PLANNING AND COMMUNITY DEVELOPMENT
 CRAIG DOSSEY, EXECUTIVE DIRECTOR

Subject: Academy Village Filing No. 3 Vacation and Replat- Review 2

FINAL PLAT
ACADEMY VILLAGE FILING NO. 3

Re: **Planning and Community Development Review of VR-17-01 – Academy Village, Filing No. 3, Second Submittal – Comment Response**

ACADEMY VILLAGE FILING NO. 3

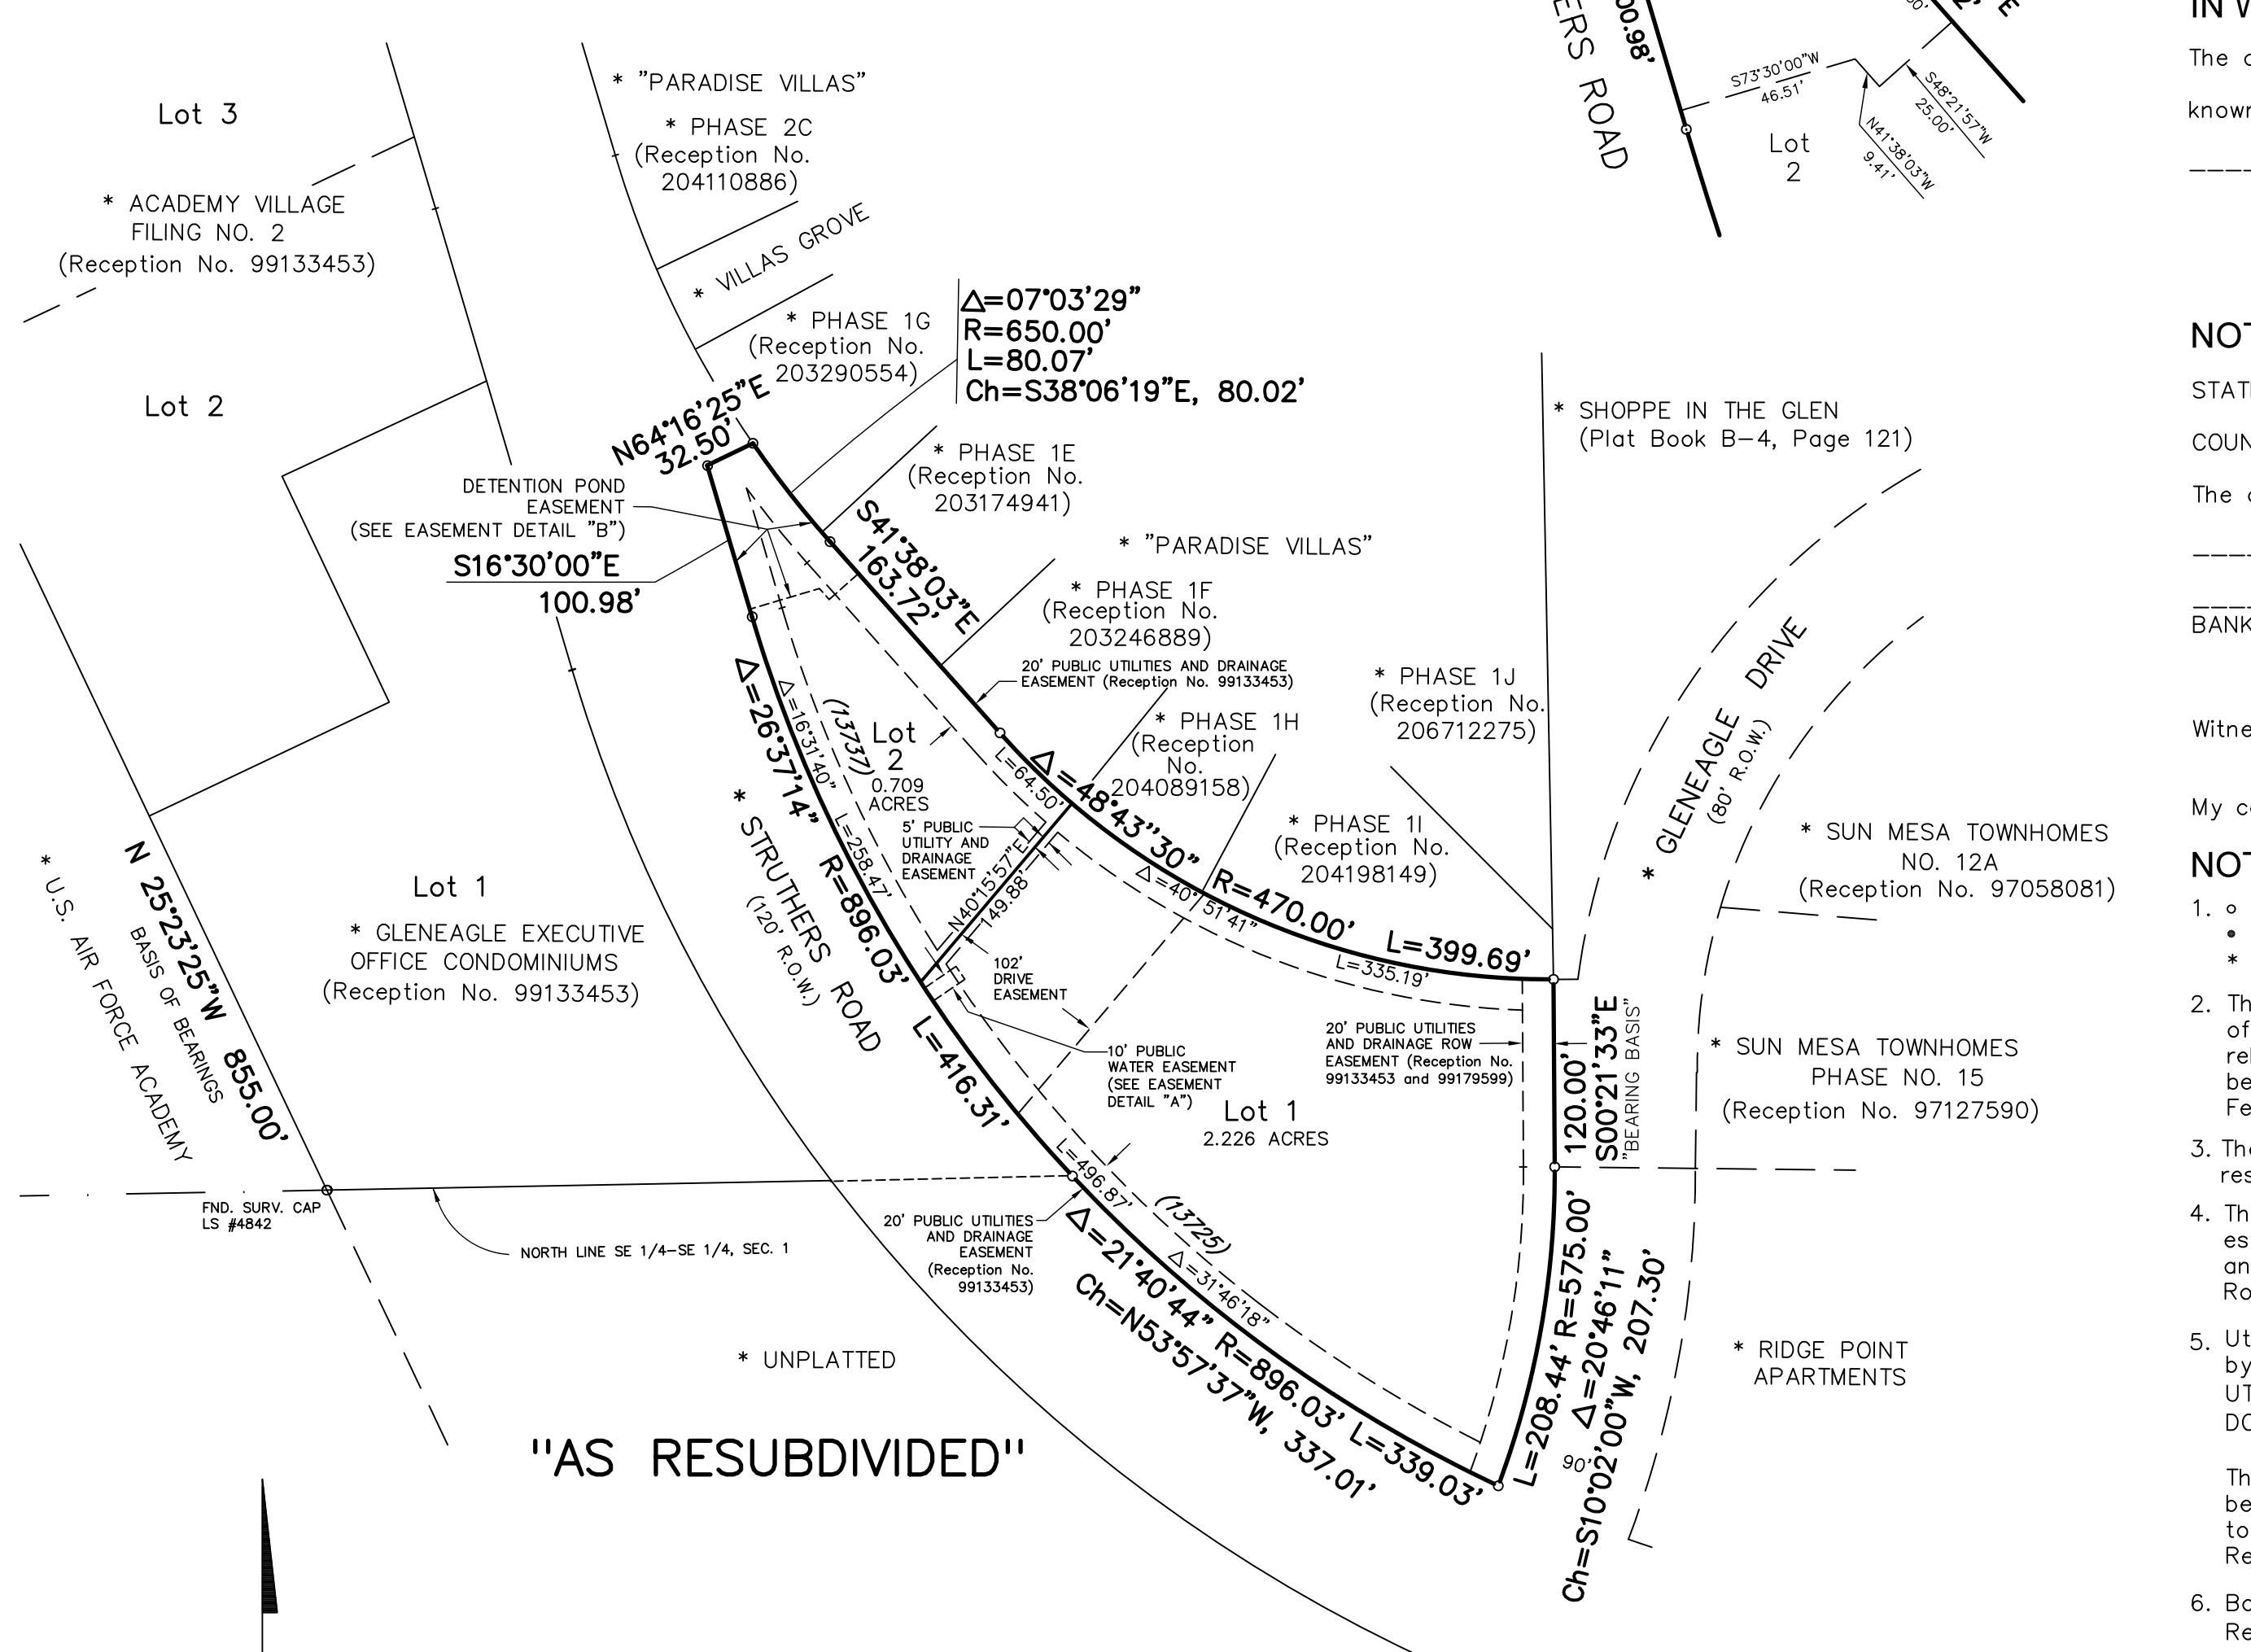
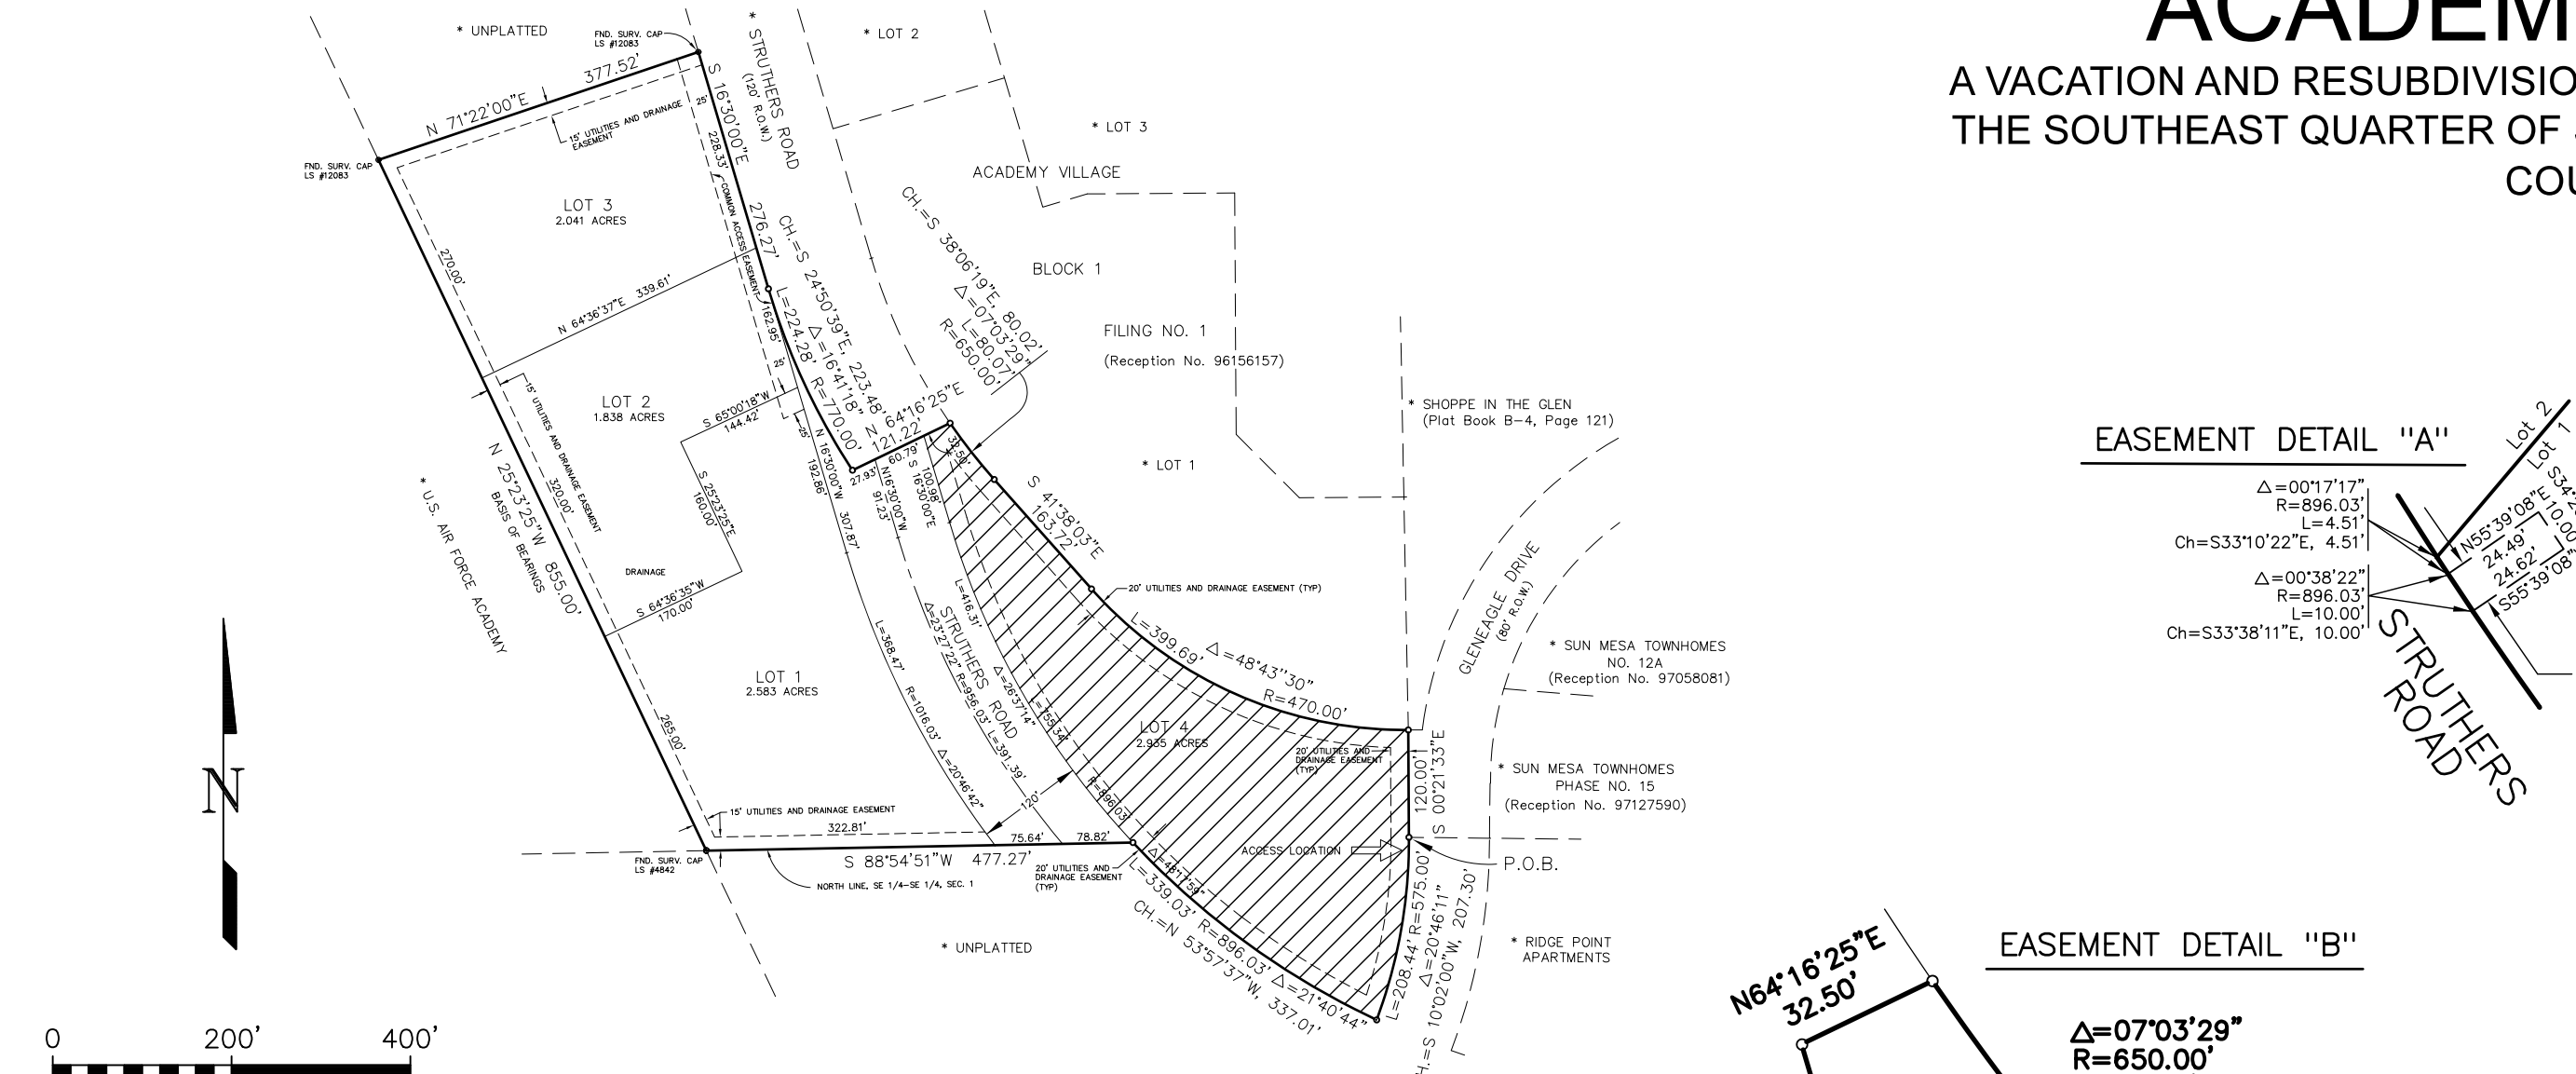
Multiple easements exist based on the title commitment. Identify and show reception numbers or book and page of easements per the title commitment. If some are to be vacated identify on the plat.

The corresponding note identifying the recorded maintenance agreement has been deleted. It was note 15. Please add it back.

PUT BACK WITHIN NOTE 18 - DVH

ALL APPLICABLE EASEMENTS NOTED ON "AS RESUBDIVIDED" DRAWING... NOT APPLICABLE TO "AS PLATTED" DRAWING - DVH
